5 April 2022

**RE: Lang Walker AO Medical Research Centre – LWMRB, Macarthur – SSD-17491477 Response to Submissions - Accessibility Statement – Rev C**

The purpose of this letter is to advise that we have undertaken a preliminary disability access assessment of the proposed Response to Submission requirement relating to transport and accessible car-parking for the proposed development as prepared by BVN Architects (refer Section 1.2 Transport - BVN report, revision C, dated 11.03.2022) with particular regards to:

Figure 2b – Mobility Impaired Car parking Location - excerpt from BVN Report

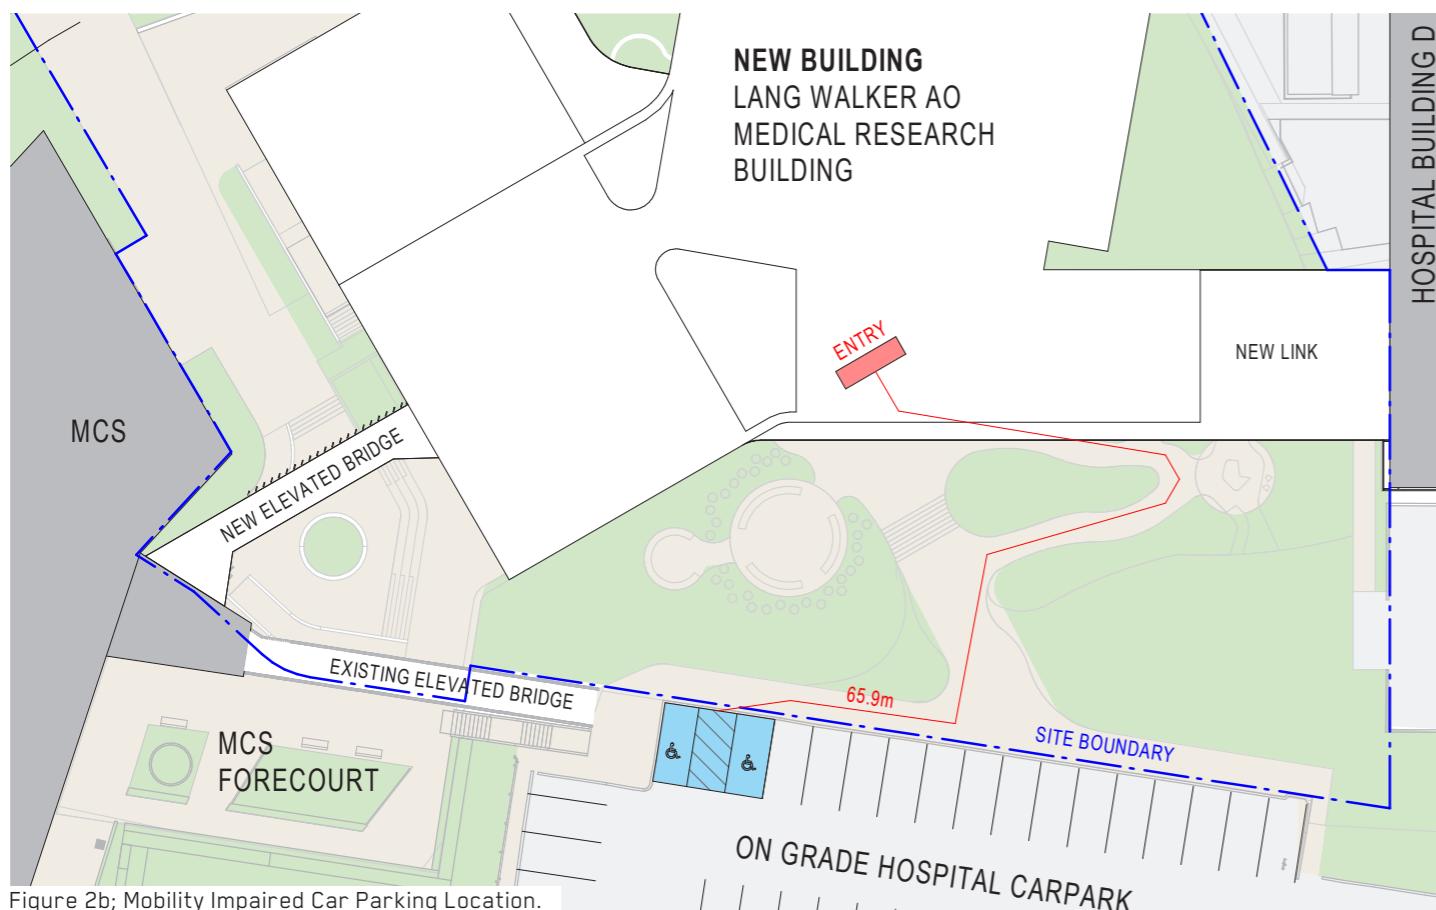
*An indicative layout plan is to be submitted showing the location and walking distances to the research centre's assigned standard and mobility impaired parking spaces. In addition, access routes from mobility impaired car spaces must also confirm that direct travel paths and suitable gradients are provided to future staff and visitors.*

As outlined in the BVN report, the proposed locations, and distances of the dedicated car-parking spaces to the building main entry at the Village Green are as follows; standard car-parking spaces to be located in the CP2 area (approx. 170m distance), and accessible car-parking spaces to be located adjacent to the existing MCS building and in front of the new LWMRB building (approx. 66m distance) as shown below:

Based on the information provided, we support the proposed location of the accessible car-parking spaces illustrated above. In our opinion these locations are capable of providing a reasonable and direct path of travel to the building main entry via the Village Green accessible pathways and stairs and the preliminary spatial layout indicates the design is capable of meeting relevant Access Standard AS2890.6:2009.

- The accessible car-parking spaces satisfy all AS2890.6 design requirements in terms of min. spatial dimensions, gradient, crossfall, design details, bollard, line-marking, signage etc.
- A connecting accessible path of travel, compliant with AS1428.1:2009 is to be provided between accessible car spaces the building entrance ie. compliant kerb ramp access to footpath with adequate landings, circulation path clearances, gradients and crossfalls, slip resistance etc.
